## DEVELOPMENT FACILITATION TEAM

### Planning - Case Comments

**Project Number:** PR-2023-009368

**Project Name:** Farolito Senior Community

SHEET NO
SDP 4.2

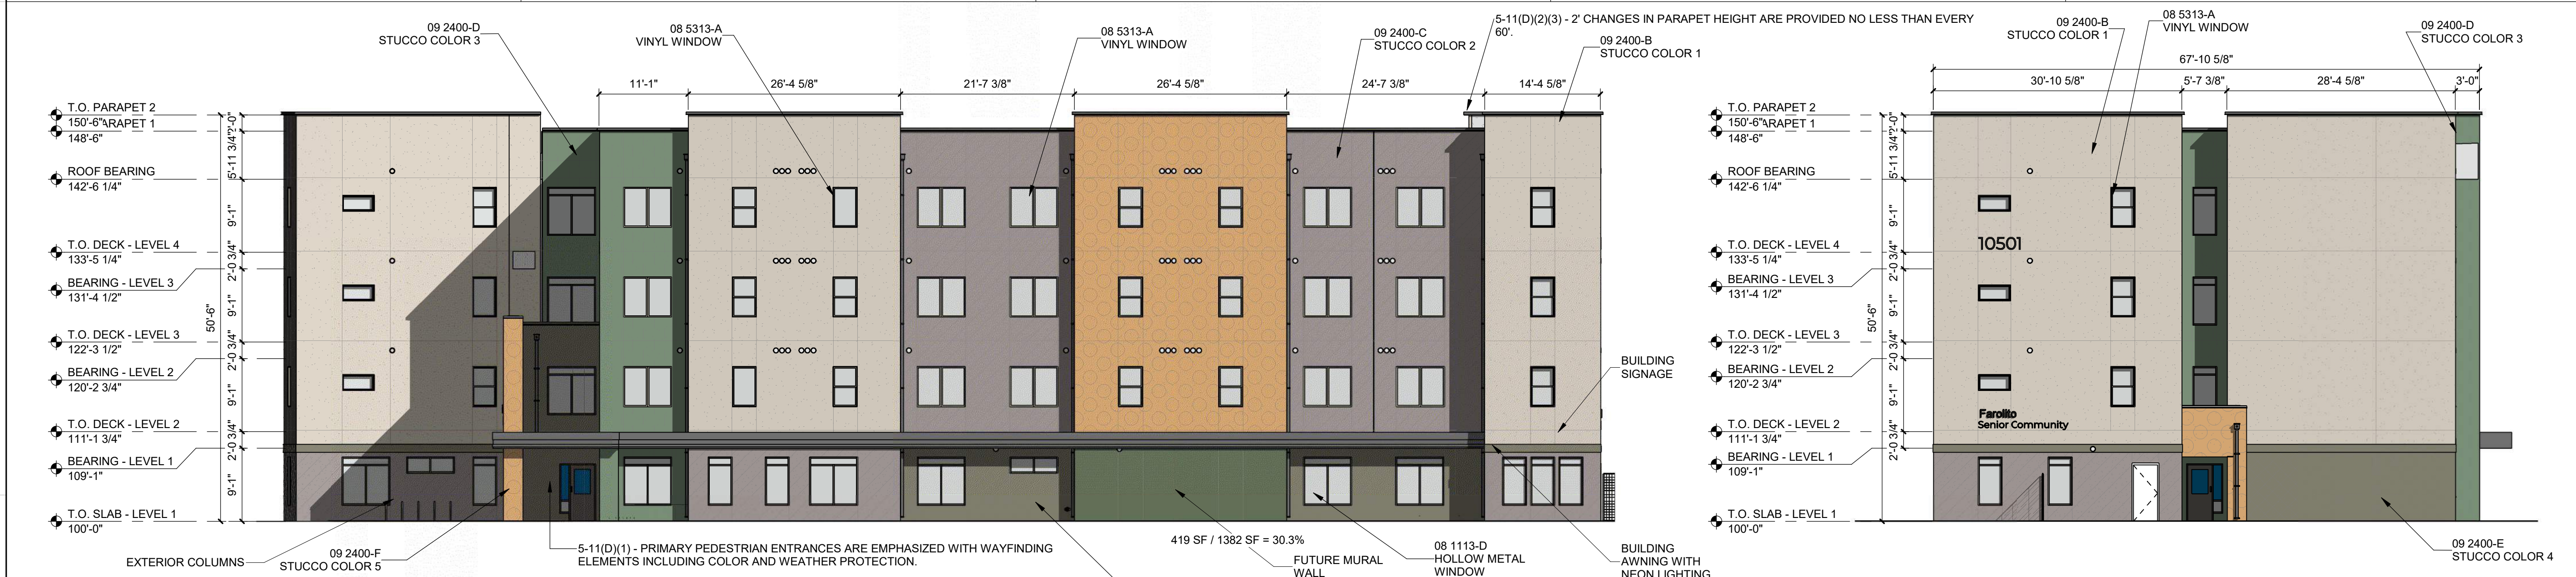
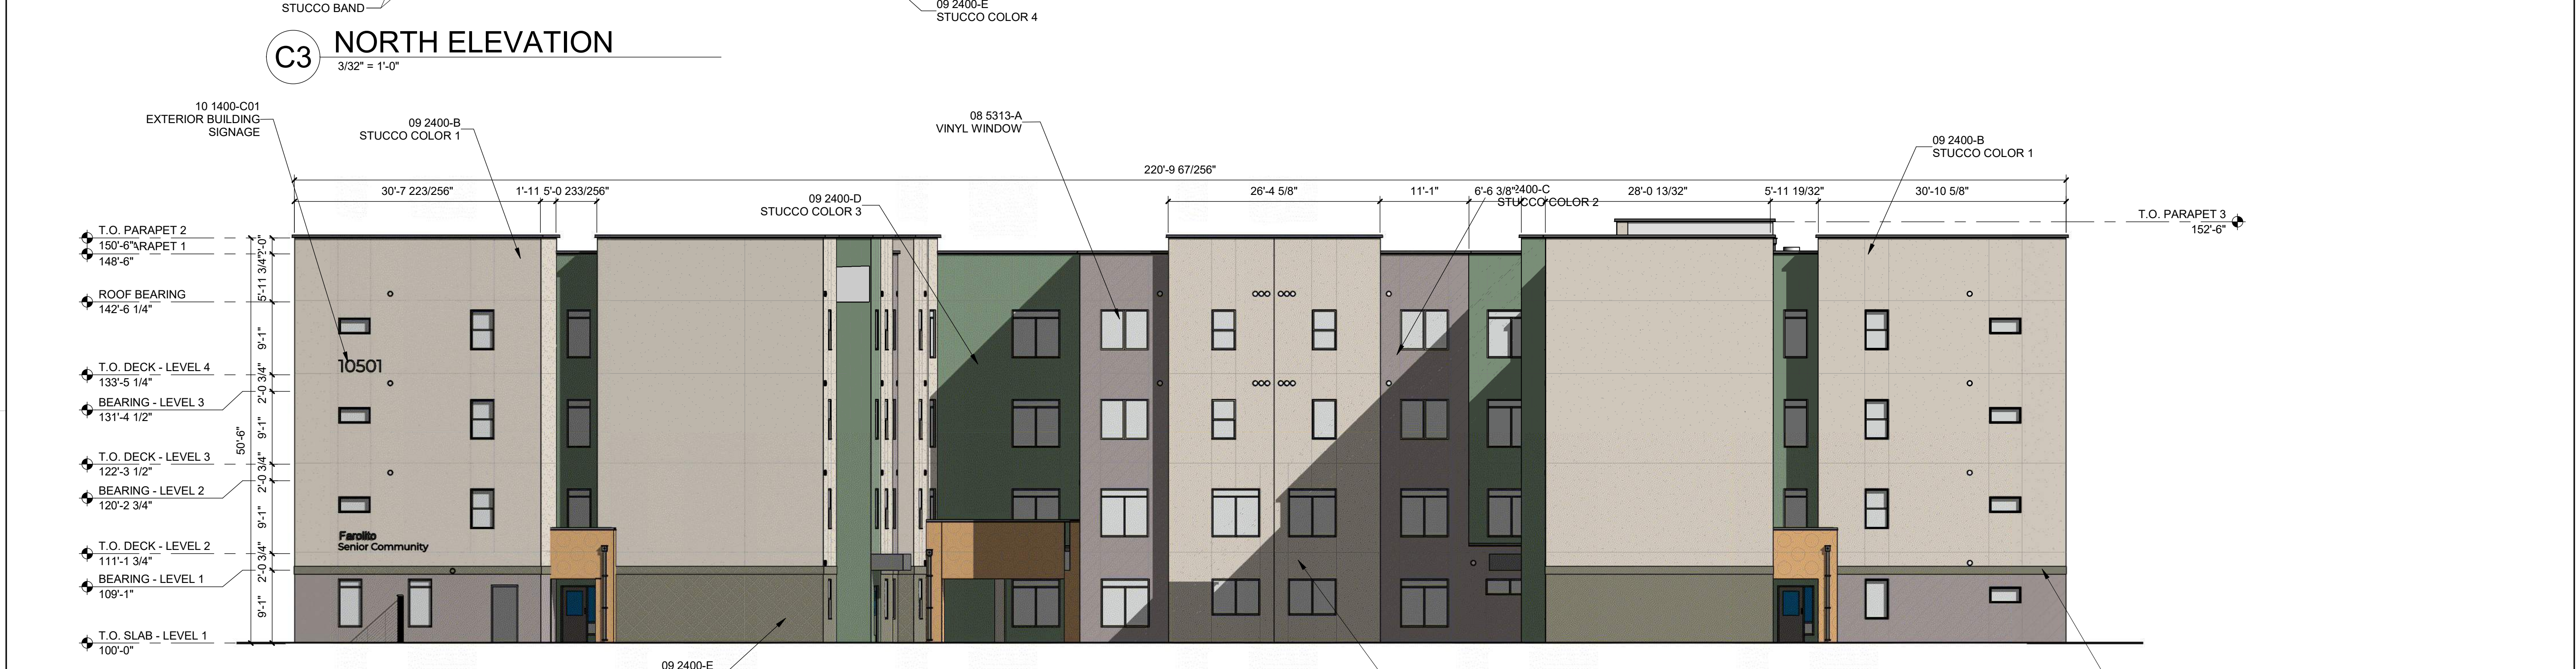
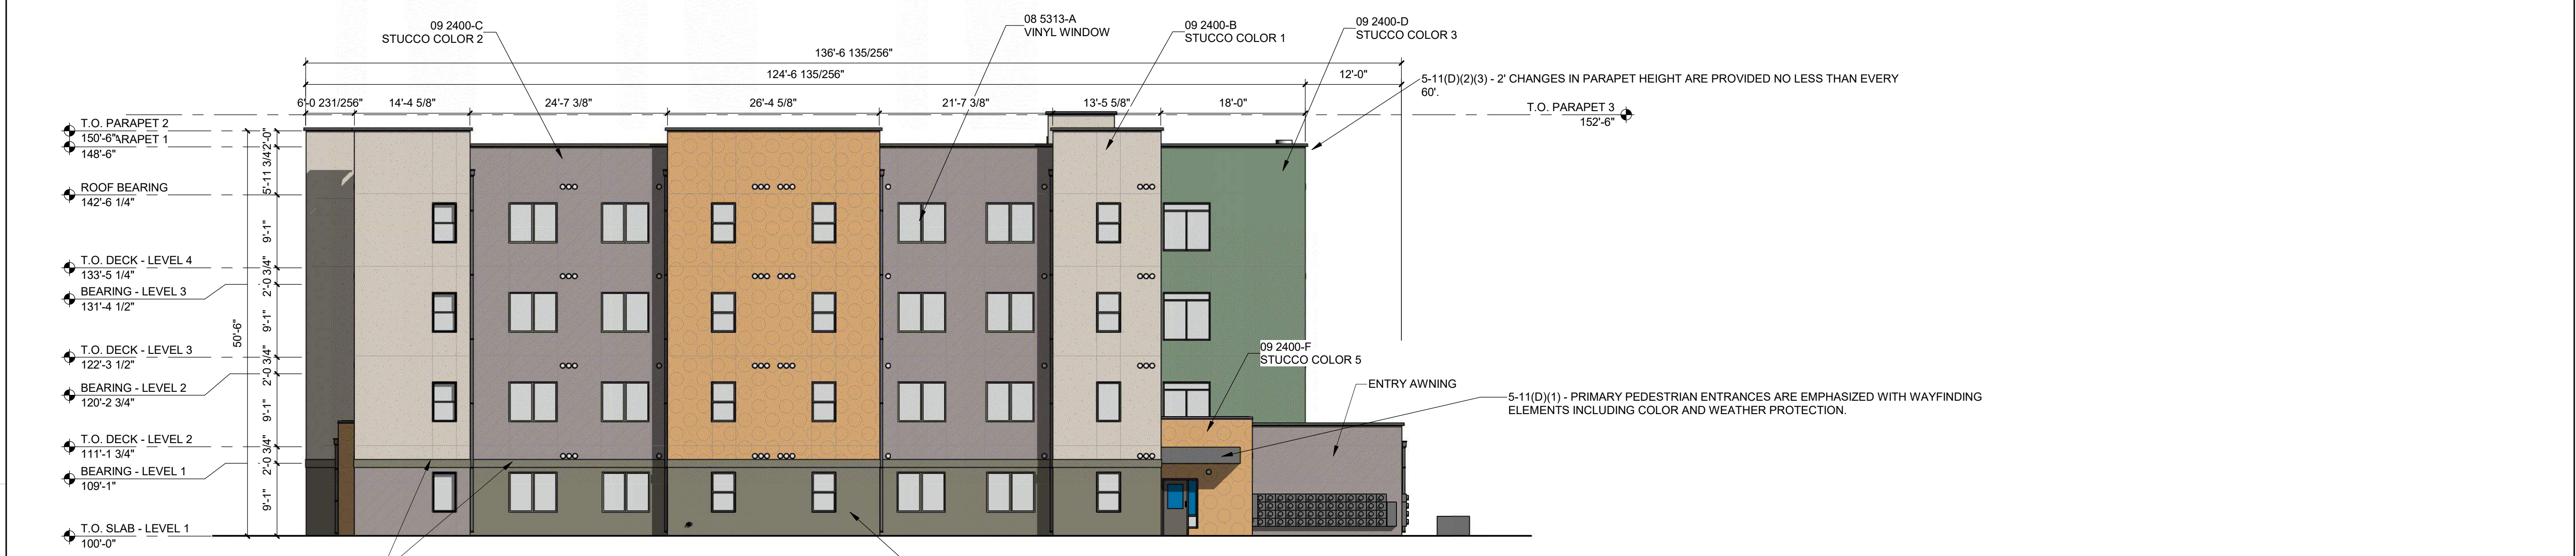
Please articulate how the facade design meets item number 2.

Design complies with this code. Please provide an explanation for the façade color selection. If the intent is to mimic the Luminaria project across the street, please

This is workforce housing.
